# KITTTITAS COUNTY

### MEMORANDUM

**TO:** All Staff  
**FROM:** Public Works Plan Review Team  
**DATE:** November 17, 2025  
**SUBJECT:** LPF-25-00006 Wildcat Plat

KITTITAS COUNTY		WASHINGTON	
DWN BY	DATE	JOB NO.	
JCR/GW/DLP	10/2025	062984	
CHKD BY	SCALE	SHEET	
DLP	1" = 200'	2 OF 3

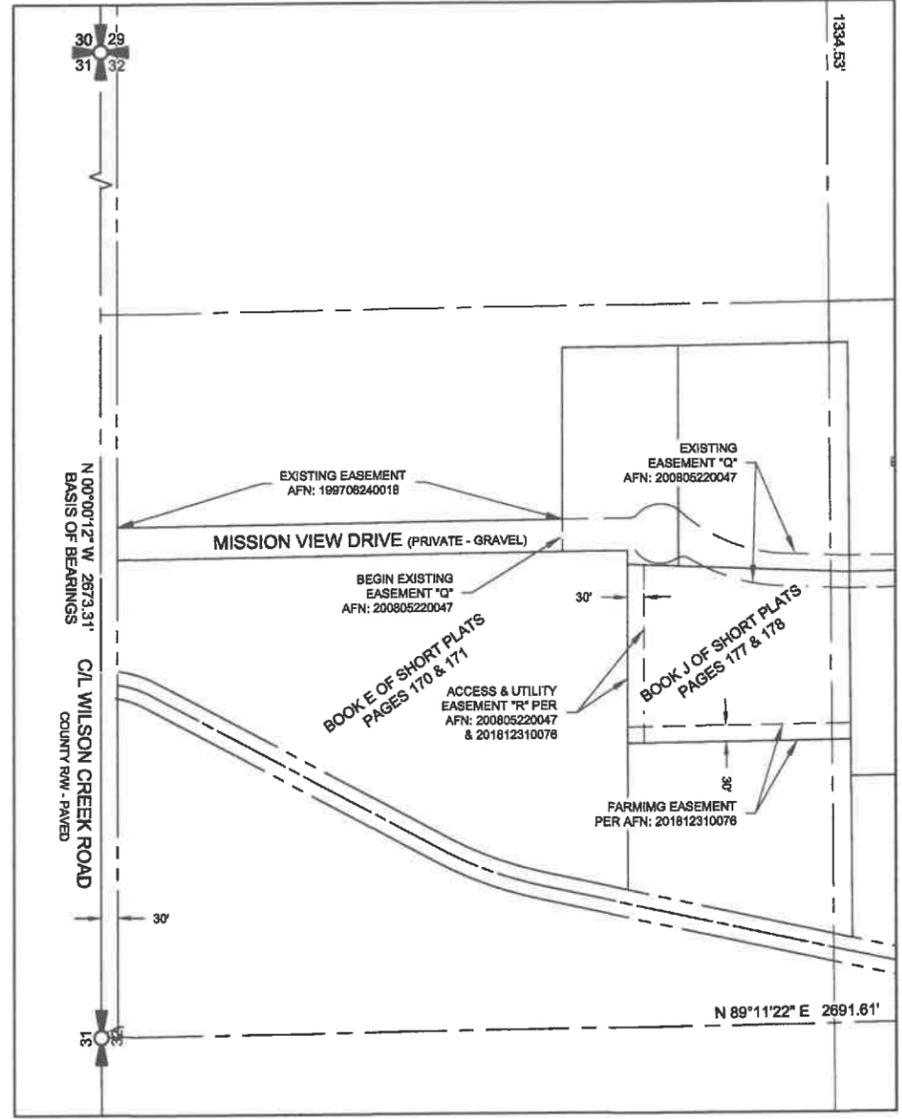
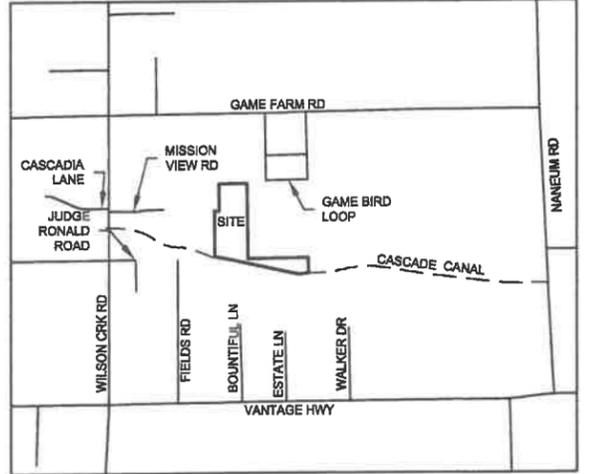
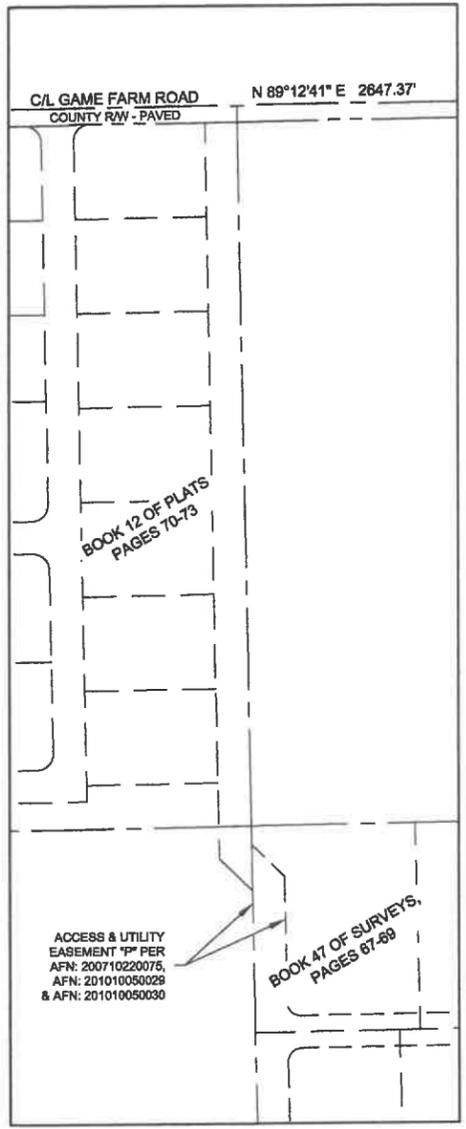
<b>SURVEY</b>	<p>1. Relating the linework between Sheet 1 and Sheet 3 is difficult. This could be made easier by labelling the center of section OR labelling the SW1/4 of NE1/4 on Sheet 1 (APN 958408).</p> <p>2. The N-S midline of section is shown as S00°43'17"E on sheet 3 and S00°43'15"E on sheet 1. (JT)</p>
<b>TRANSPORTATION CONCURRENCY</b>	<p>A concurrency evaluation and determination shall be required for all development applications in which the proposed development is projected to have an impact upon the transportation corridor or intersection.</p> <p>Developments generating 41 or fewer daily trips are exempt from the TIA and concurrency evaluation requirements. (KAH)</p>
<b>FLOOD</b>	<p>No comments. (SC)</p>
<b>WATER MITIGATION/ METERING</b>	<p>Water Mitigation and Metering requirements in KCC 13.35.027 have been met.</p> <p>No further comments. (SC)</p>
<b>AIRPORT</b>	<p>No Comments. (RC)</p>
